Reply To: at the address below
Date: 2 February 2016
Reference: 6/2015/2223/HOUSE
Direct Tel: 01707 357298
Fax: 01707 357255
Email: planning@welhat.gov.uk

45 Northaw Road East, Cuffley, Herts, EN6 4LU: Reference No: 6/2015/2223/HOUSE

Erection of single storey side and rear extensions and extension to the roof to form habitable accommodation.

North Facing Elevation windows

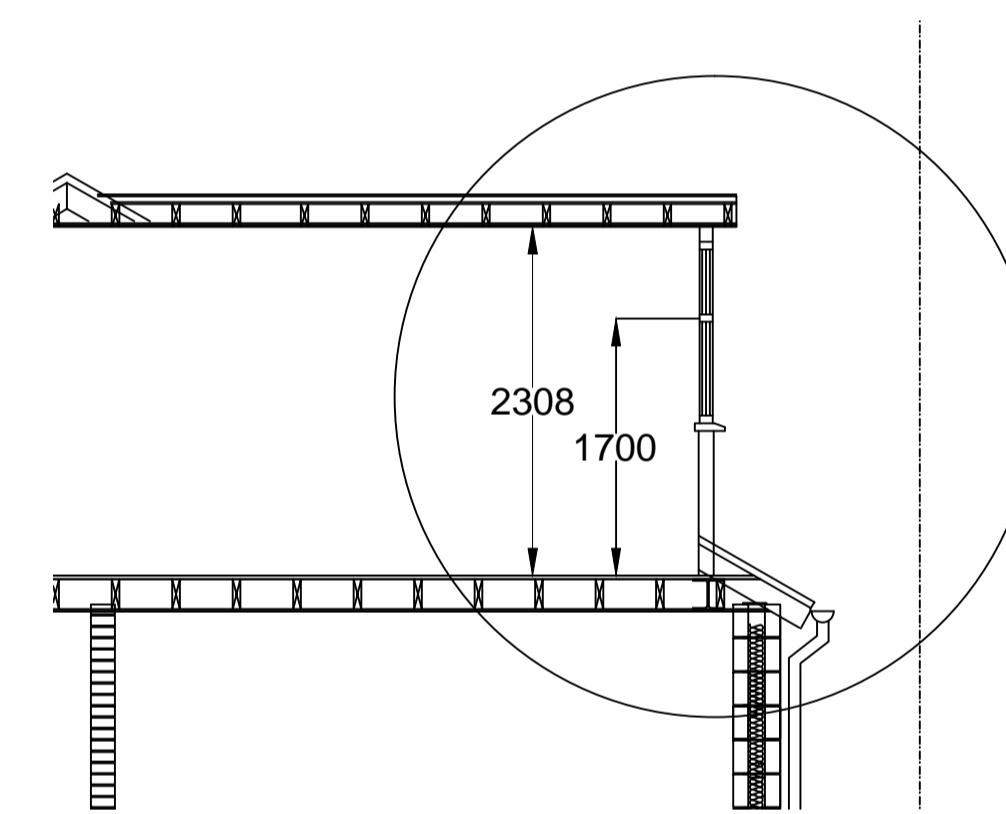
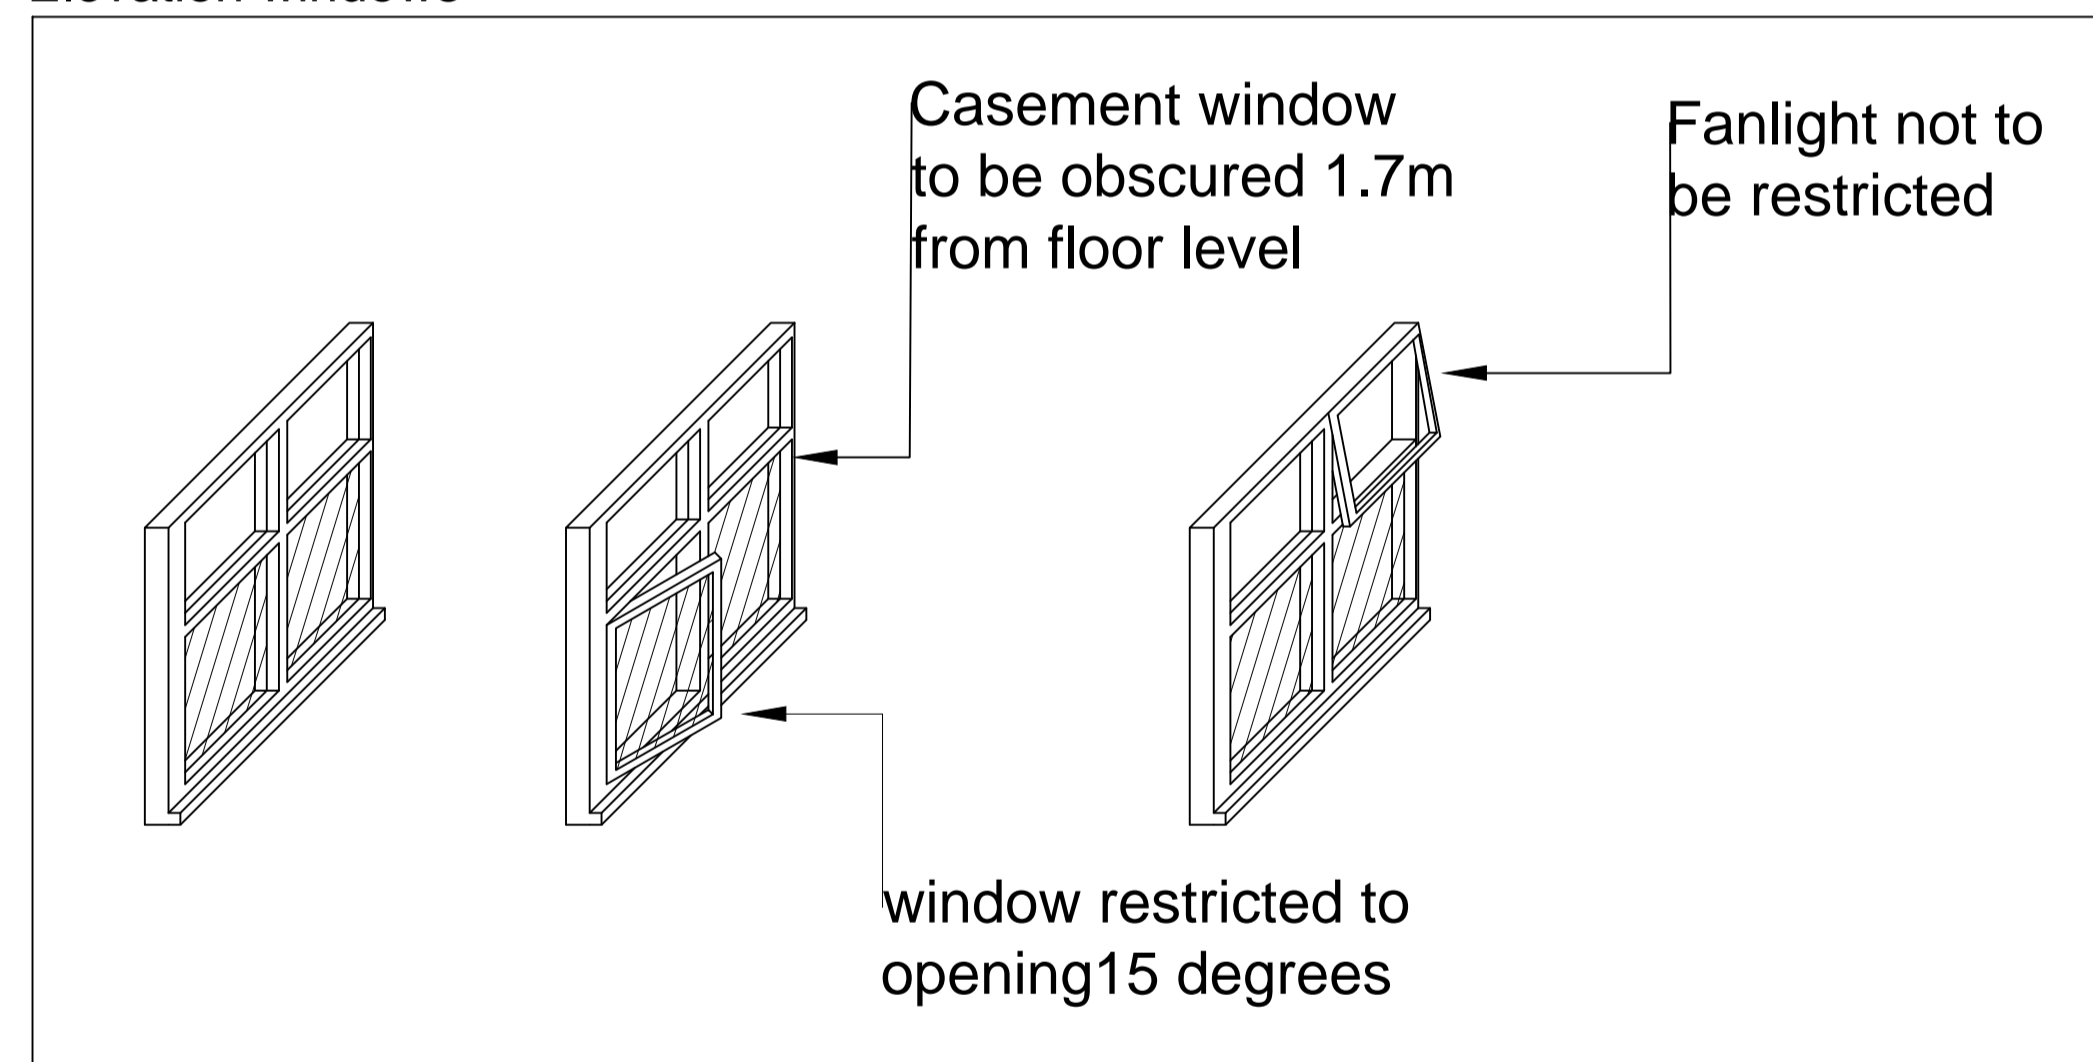
The case officer made specific comment in her report of the relationship that would result with the neighbouring properties, particularly in the light of the proposed dormer windows. You will have noted from the plan that you have considered, marked up and returned to the Council that two of the three dormer windows facing towards your rooms would serve what are considered to be secondary areas of the neighbouring property. Specifically, these windows would serve a dressing room and en-suite bathroom and a bathroom and a stairwell. Having regard to this, it was not considered that there would be any significant and material loss of privacy by way of overlooking to your property. The third dormer window would be one of two windows serving a bedroom. The case officer considered in her analysis that, whilst there would be the capacity for some increased overlooking as a result of this window, it was not considered to be so significant so as to warrant the refusal of planning permission.

Having said all of that, I have been in contact with the architect who submitted the planning application on behalf of the owners of number 45 Northaw Road East. I have requested that his

client considers the application of obscure glazing to this window such that the window would be obscure glazed up to 1.7 metres above the floor level of the room that it would serve. At the time of writing I am awaiting a response from the architect.
